Engineers Comments Regarding Surface Water Drainage

Application Reference:	WA/68/26/PL	Reviewer Reference:	ADC/EXT5/AF
Planning Officer:	Hebe Smith	Date of Review:	17/08/2026
Site Name:	The Greenway West Walberton Lane Walberton BN18 0QS		
Application Description:	Construction of a self-build/custom build single dwelling, with garage outbuilding and associated works. This is a departure from the local development plan and is in CIL Zone 3 and is CIL liable as a new dwelling.		
Assessment Number:	1

Drawing Title Topographic Land Survey

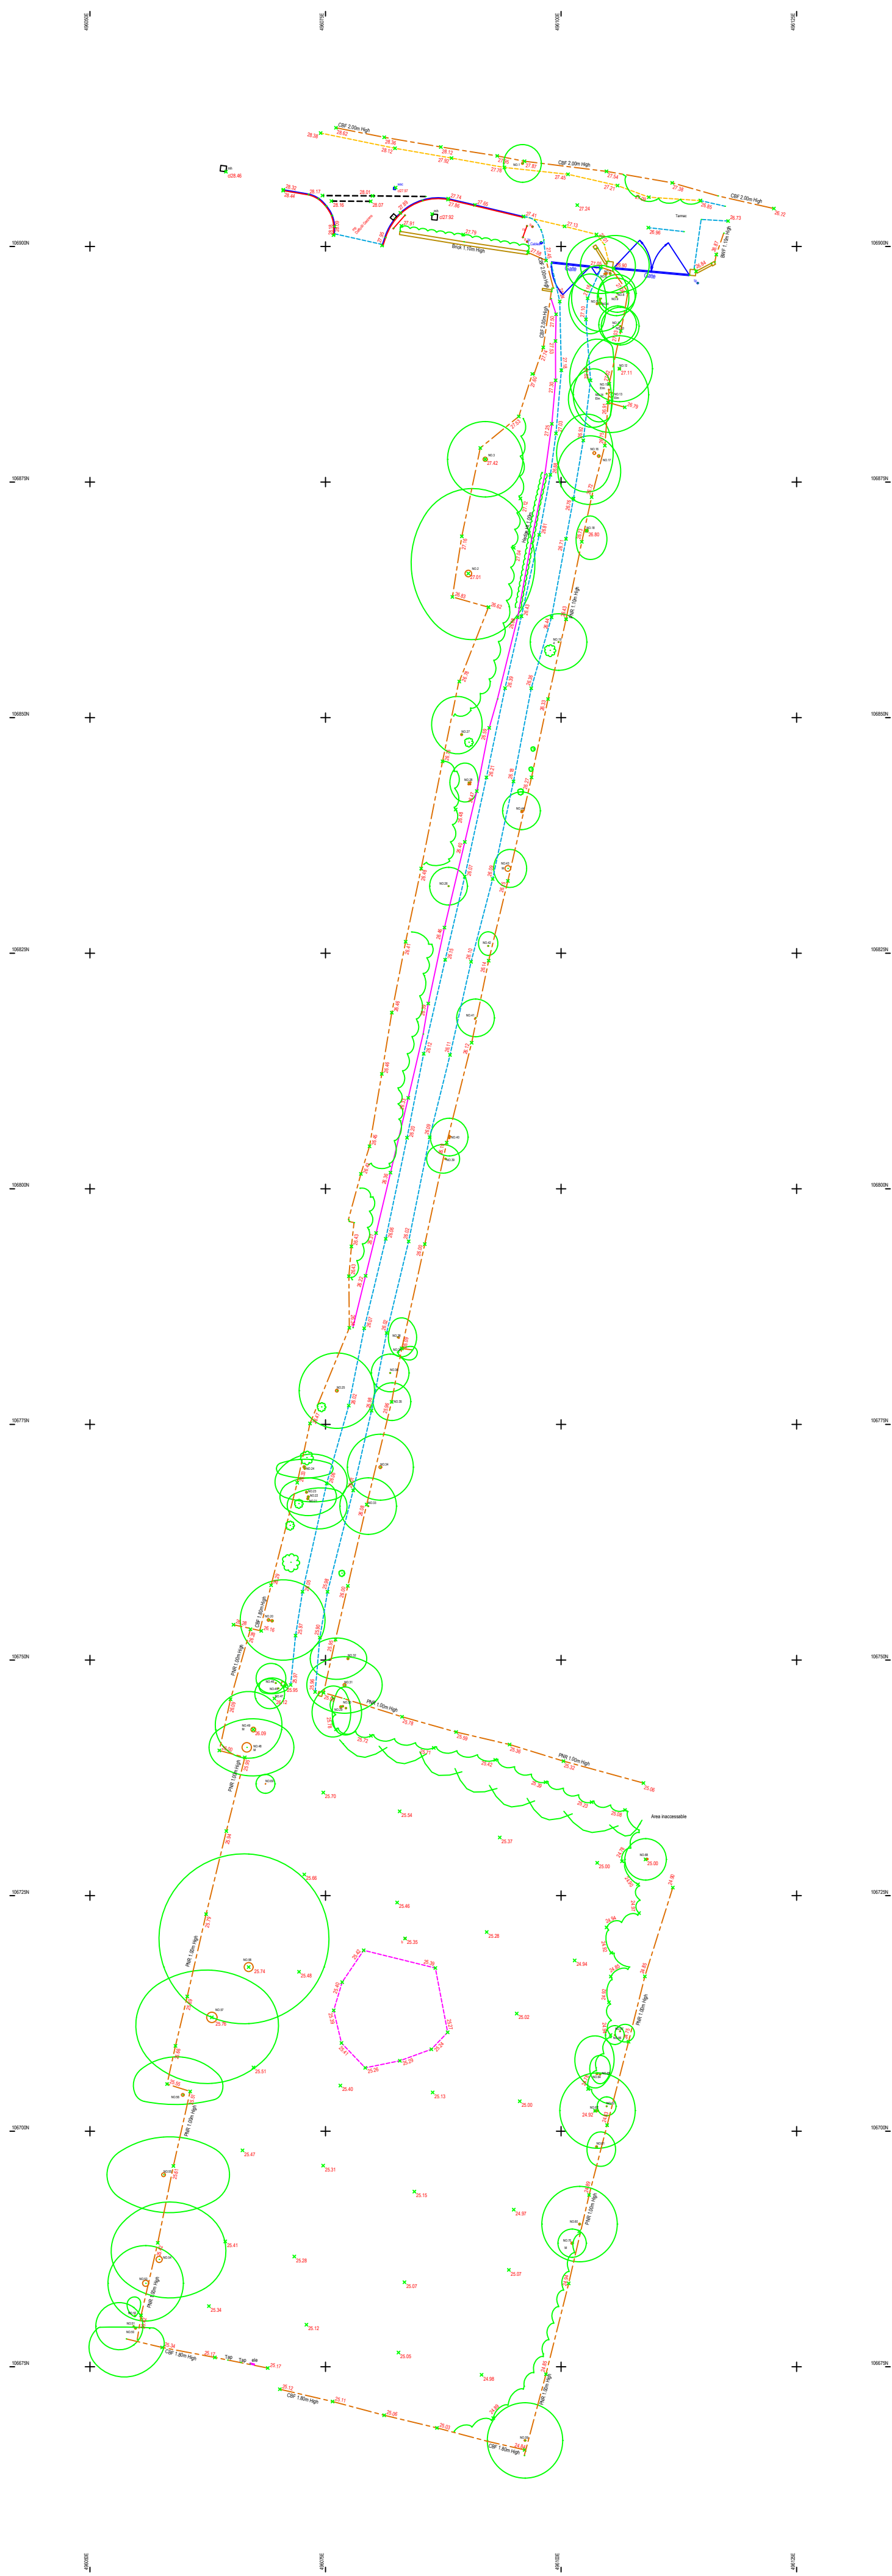
- 1.3. Infiltration tests were undertaken at depths of 1.0 m and 1.05 m below ground level. The permeable paving adjacent to the dwelling appears to have a depth of approximately 600-700mm below ground level depending on the finished levels design. The ground investigation is sufficient for planning stage to demonstrate the feasibility of the strategy. Further investigation at the location and depth of the proposed features will be required at discharge of conditions stage to evidence the effectiveness of the technical design.

- 3.1. The FRADS includes drainage plans and modelling. The design is well progressed for planning stage. **However, due to the resolution, we are unable to fully review the detail.**
- 3.2. The areas, base gradients, depths and effective storage depths of permeable paving is not clear from the calculation outputs. Evidence of drainage model inputs should be provided.
- 3.3. Clarification is required as to how the permeable driveway with existing trees is designed and included in the drainage calculations in terms of how the storm water will be stored whilst retaining root protection / 'no dig' construction. Proposed base levels should be shown in comparison with the topographic survey.

Land north of The Green Way
Appendix 6 - tree protection plan

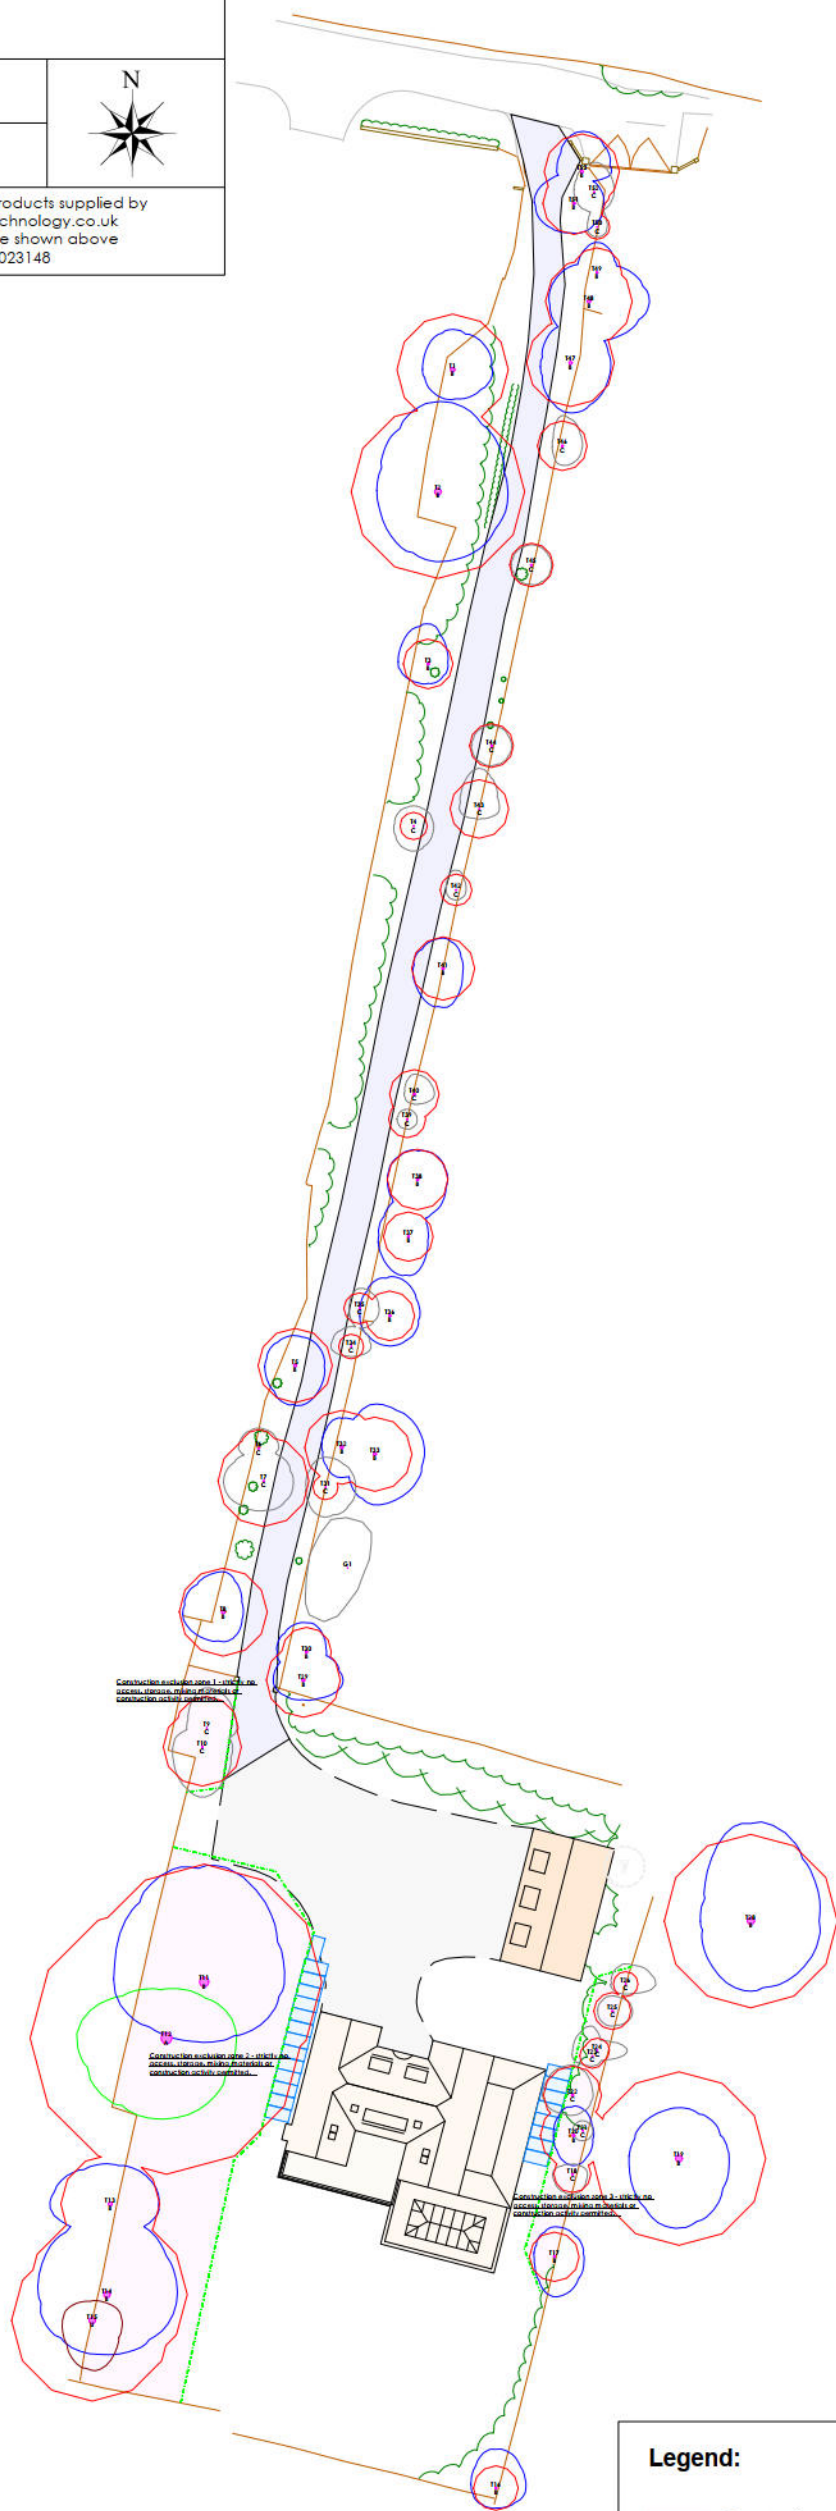
- 0.5. The existing trees adjacent to the access drive have root protection areas that requires root protection / 'no dig' construction.
- 0.6. The application is supported by a Flood Risk Assessment and Drainage Strategy [FRADS] which is updated following our comments on the previous application. **However, we are unable to read the text on the drainage layout plan due to low resolution and are therefore unable to fully review the design against the calculations.**

7.2. There are a significant number of good quality trees on the site, most of which are to be retained. These existing trees are a constraint to the drainage strategy as any drainage installations should not damage the trees, and the drainage infrastructure itself needs to be protected from tree root damage. The design as submitted demonstrates areas of conflict with the existing trees and their current root protection areas which will require root protection construction methods. Further information is required to demonstrate the design is feasible.
